**Planning Act 2008**  
**Application by Highways England for an Order Granting Development Consent for the A303 Sparkford to Ilchester Dualling**  
**Submission for Deadline 1**

## **A303 Sparkford to Ilchester Dualling Scheme**

**PINS Reference: - TR010036**

### **Summary of South Somerset District Council's Relevant Representation**

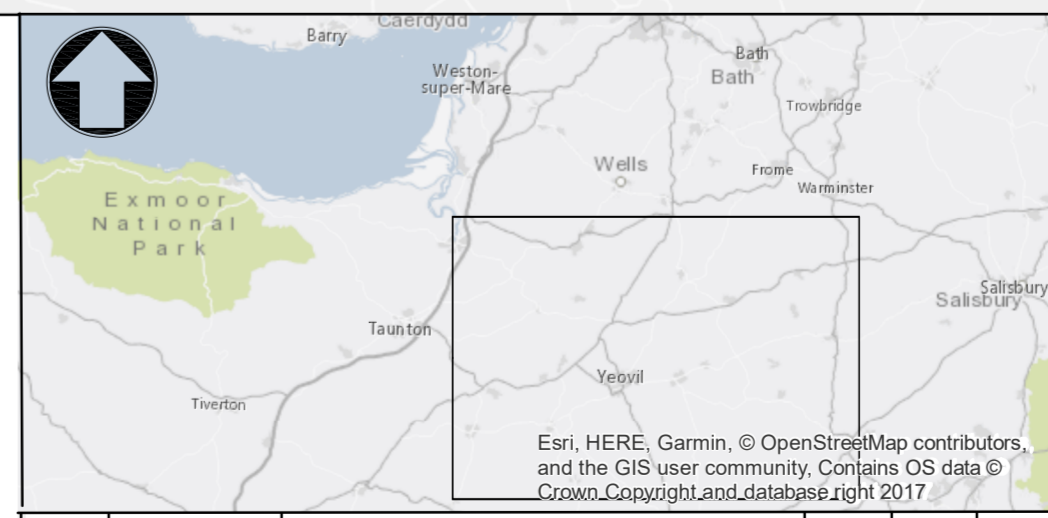
- Baseline information and assessment methods used to model air quality is satisfactory.
- Two potential areas of concern - West Camel and Sparkford High Street. Further investigation may be needed to ensure these areas will not exceed air quality limits.

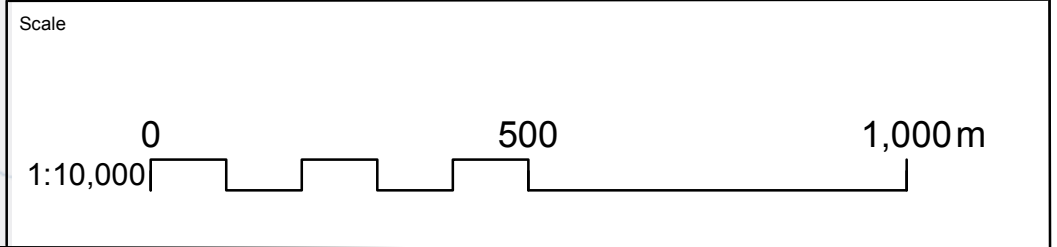
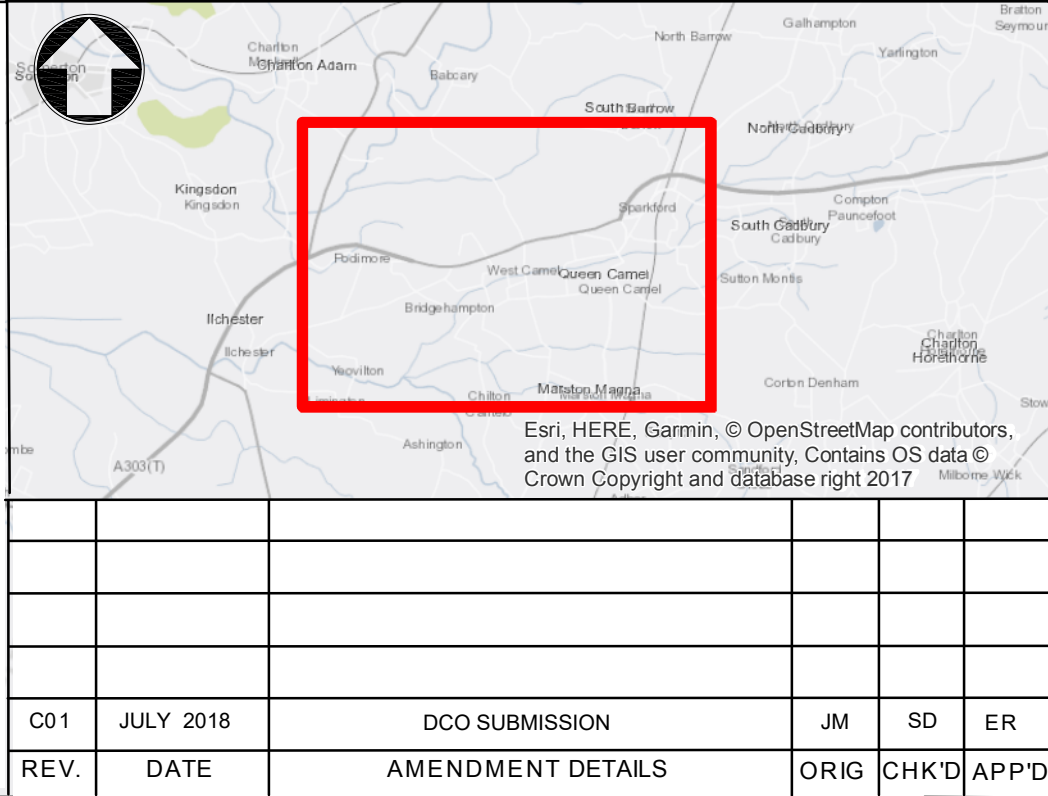
- Baseline information and assessment methods used to model noise and vibration is satisfactory and clearly demonstrate the likely effects of the proposed scheme during construction and operation.
- Two potential areas of concern - West Camel and Sparkford High Street. Further investigation may be needed.

Drawing Title  
**FIGURE 12.4  
BUSINESSES IN THE LOCAL IMPACT AREA**

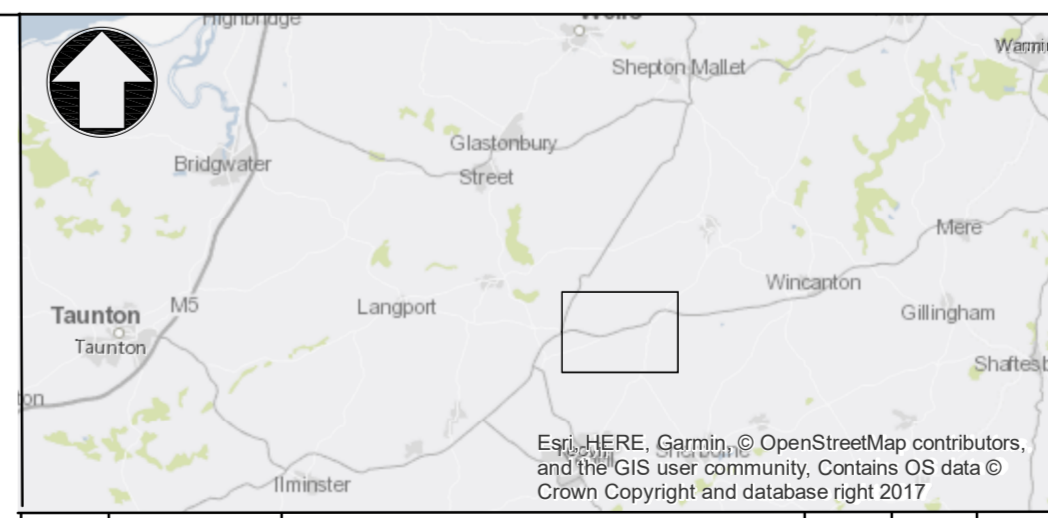
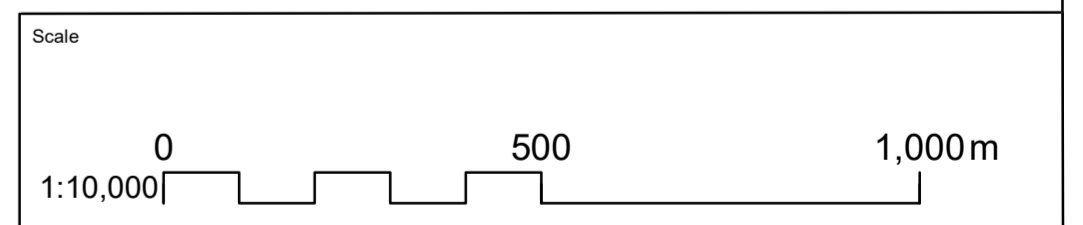
- Any new signage strategy should consider impact on the viability of local businesses.
- The defined Local Impact Area for businesses is restrictive and should be widened.
